# CITY OF ALBUQUERQUE

August 9, 2021

**Re: Dutch Bros Coffee  
Project Address ???  
Traffic Circulation Layout  
Engineer's Stamp 07-30-2021 (B10-D003I)**

C-100

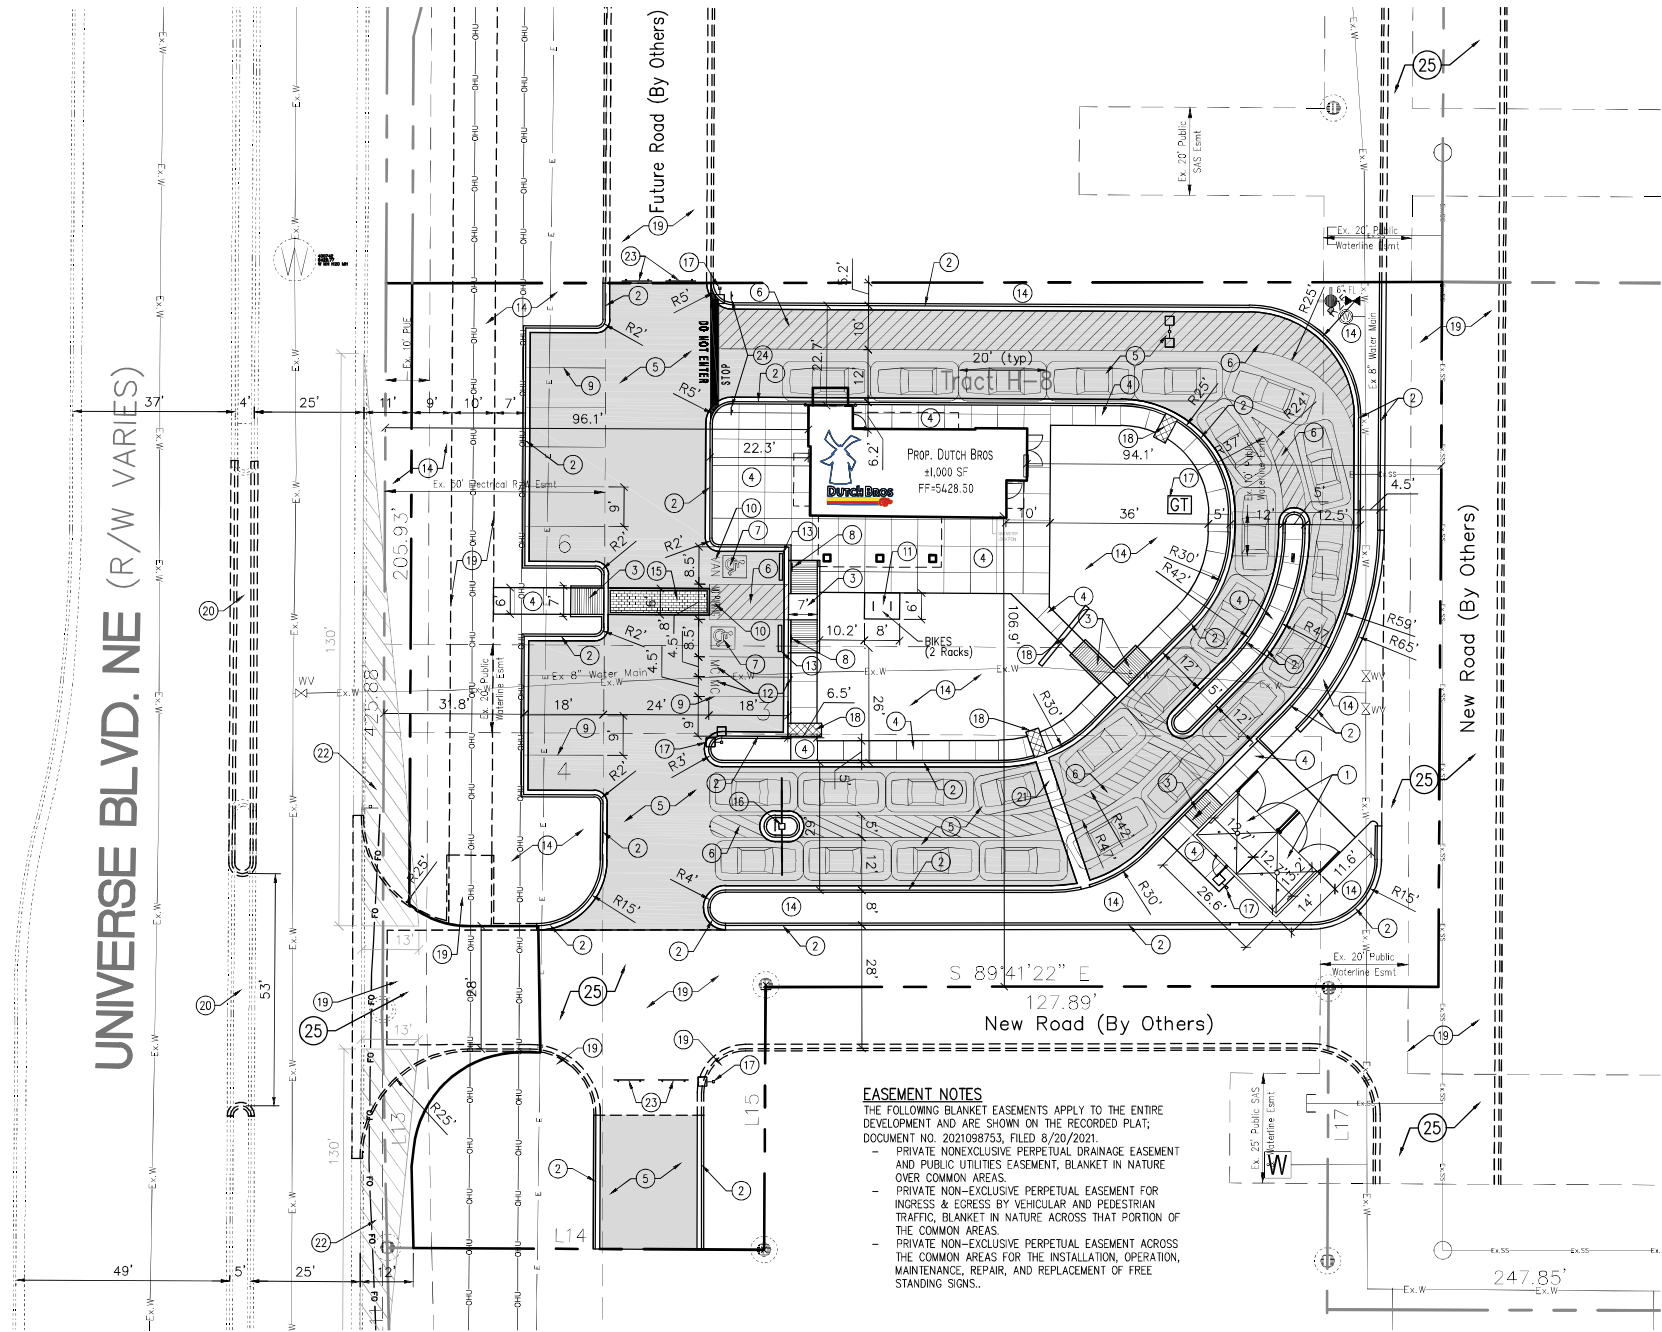
**1. Work Order will be needed for the following concerns (Keyed Note 19);**

- Asphalt trail fronting Universe Blvd.
- Proposed entrance/driveway (includes geometry, ADA ramps[ both sides of entrance/driveway, etc...)
- Auxiliary Access Road infrastructure, sidewalk, and curb and gutter requirements.
- Universe Blvd: Remove construction note for median cut since there existing a median cut.

2. A secondary access point (**For Emergency vehicles**) will need to be provide to existing Access Road off Universe Blvd. This will include 24 ft of asphalt roadway and details provided.

3. **End treatment (traffic devices and signage) will need to be shown off the primary entrance to the south and to the north of proposed drive aisle to alert traffic that pavement and drive aisle end.**

5. Identify the right of way width, medians, curb cuts, and street widths on **Universe Blvd Nw and the auxiliary Access Road behind the development.**

- **Provide entrance width (not shown on site plan off Universe)**

7. The ADA accessible spaces must include an access aisle. **Van accessible aisles should be 8ft wide**; all others should be 5ft wide. **Dimension not clearly shown.**
8. ADA curb ramps must be updated to current standards and have truncated domes installed (**Entrance/driveway off Universe**).

15. List radii for all curves shown; for passenger vehicles. **Radius for delivery trucks, fire trucks, etc. is 25 ft. or larger.**
16. **FD approval will be needed for the proposed layout.**
17. Per the IDO, a 6 ft. wide ADA accessible pedestrian pathway is required from the public sidewalk to the building entrances. Please clearly show this pathway and provide details. **Dimension not shown clearly.**

18. Per DPM, a 6 ft. wide ADA accessible pedestrian pathway is required from the ADA parking stall access aisles to the building entrances. **Please clearly show this pathway and provide details. Please dimension.**

19. All sidewalks along streets should be placed at the property line **(Auxiliary Access Road)**.
20. Provide a copy of refuse approval.
21. All one-way drives shall have "One Way" and "Do Not Enter" signage and pavement markings. Please show detail and location of posted signs and striping.

22. The minimum drive through lane width is 12 feet with a 25 foot minimum radius (inside edge) for all turns. (A 15 foot radius can be used with an increase in lane width to 14 feet). Please dimension all lane widths and radii.

23. Please provide a sight distance exhibit
24. Show the clear sight triangle and add the following note to the plan: "Landscaping and signage will not interfere with clear sight requirements. Therefore, signs, walls, trees, and shrubbery between 3 and 8 feet tall (as measured from the gutter pan) will not be acceptable in the clear sight triangle.

27. **Add a note stating** "All broken or cracked curb & gutter." A build note must be provided referring to the appropriate City Standard drawing **(2415A)**.
